Please note I wish this objection/material consideration to be attached against Planning Application P/58/19/PL, land rear of Inglenook Hotel Pagham Rd., Pagham this document questioning referral and subsequent Wilbar RSA and WSCC lack of objections to the traffic issues as explored in this document.

There may be references to the 2 Wilbar Associates Ltd. traffic documents, the first dated 30/12/19 called Transport and Highways Review, and the second dated 15/1/20 called RSA Stage 1. The references stated would be abbreviated to THR and the para no. or RSA and the para no.

Refuse Vehicle
Swept Path Analysis

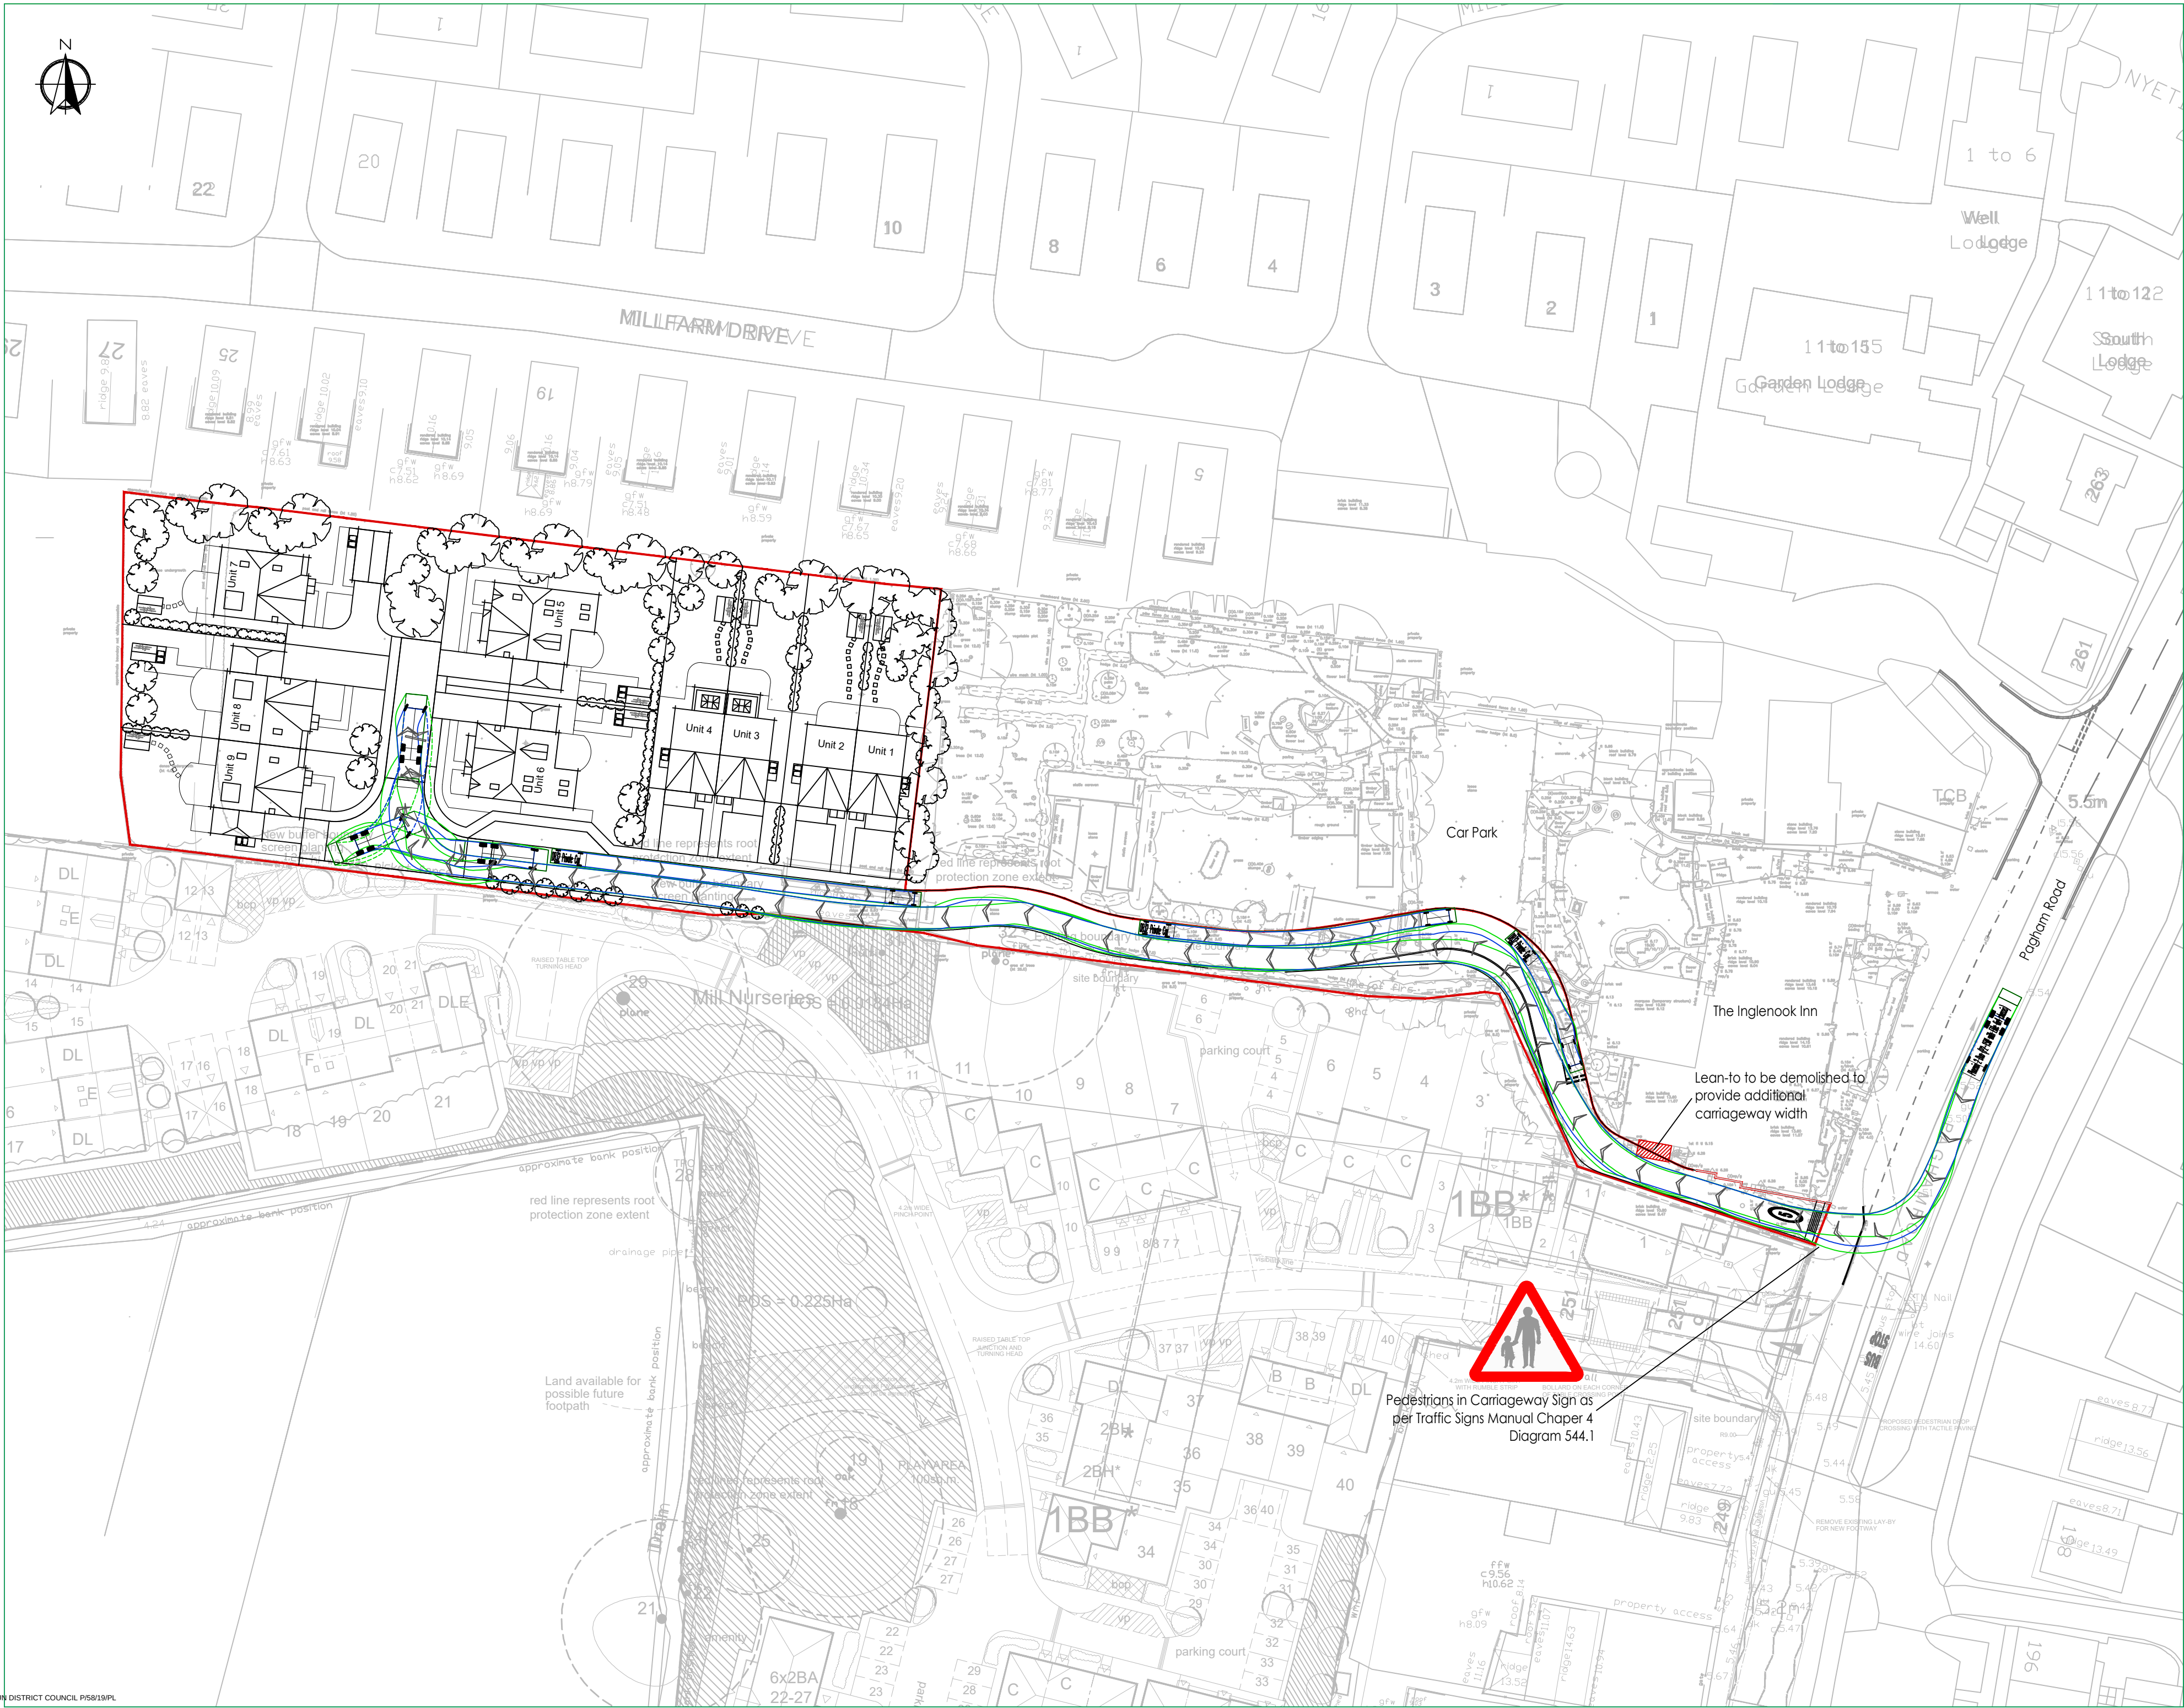
The THR p 5.1.1 passes comment that a refuse vehicle would not be able to exit on a safe swept path with the present parking arrangements on Pagham Rd. having no restrictions at the splay points.

The THR p 5.1.2 states and I quote ... "Mfs (Manual for streets) does suggest that occasional parking in visibility splays is quite common but defined bays should be provided outside visibility splays. The presence of the lay by to the North will have an significant impact to the safety with the additional flow expected from the development at peak times"
